PLANNING CONSULTATION RESPONSE

Application No	2026/0503
Proposal	Erection of single storey office building (Use Class E(g)) with ancillary attached garage/store, external storage/open storage yard, formation of parking area and erection of wall/boundary treatments.
Address	Plot 9 Unit 1, Claycliffe Road, Barugh, Barnsley, S75 1HS
Date of Consultation Reply	7 th August 2026
Consultee	Highways DC

[2nd response]

SITE PLAN
SCALE 1:200

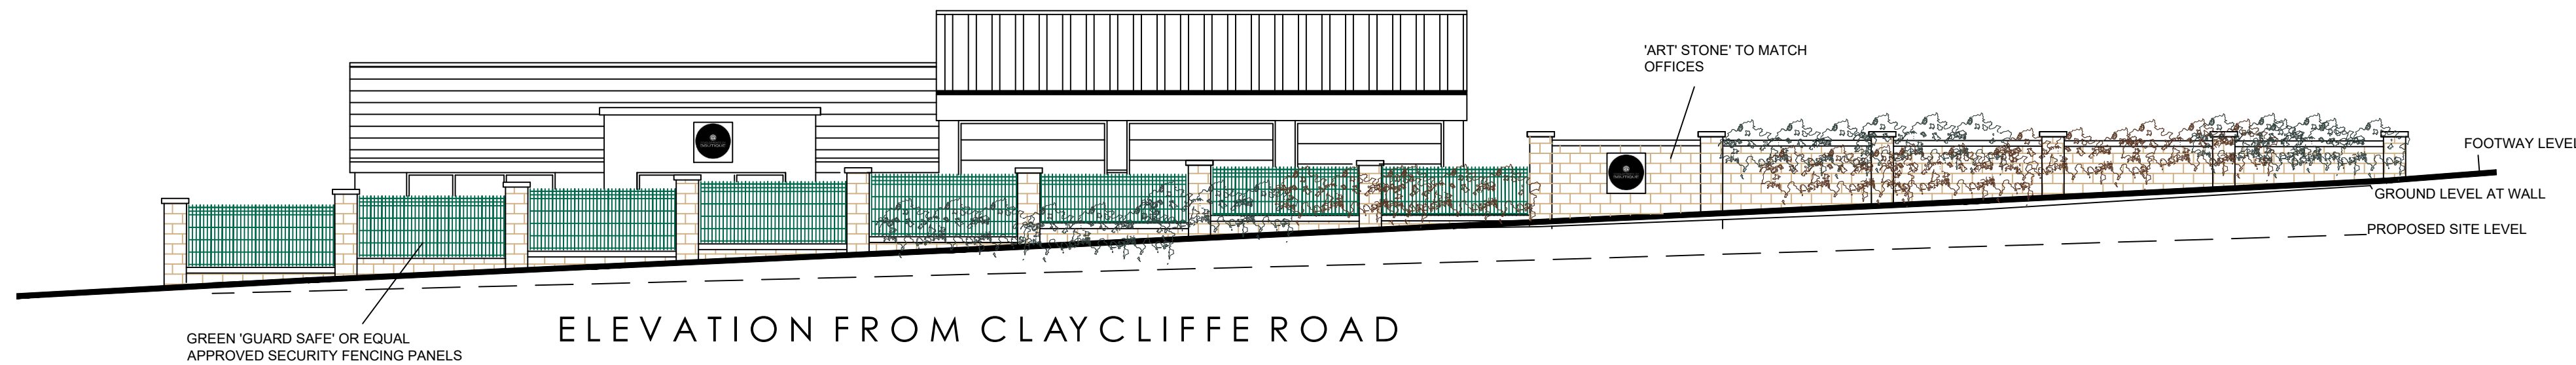
An amended site layout plan has been provided, along with a plan showing the swept path manoeuvres of a vehicle turning within the site.

A small tipper type vehicle with a length of 6.5m has been utilised for the swept path manoeuvres and the site layout has been slightly amended in order to accommodate the turning manoeuvre of the vehicle within the site; these submitted details are satisfactory.
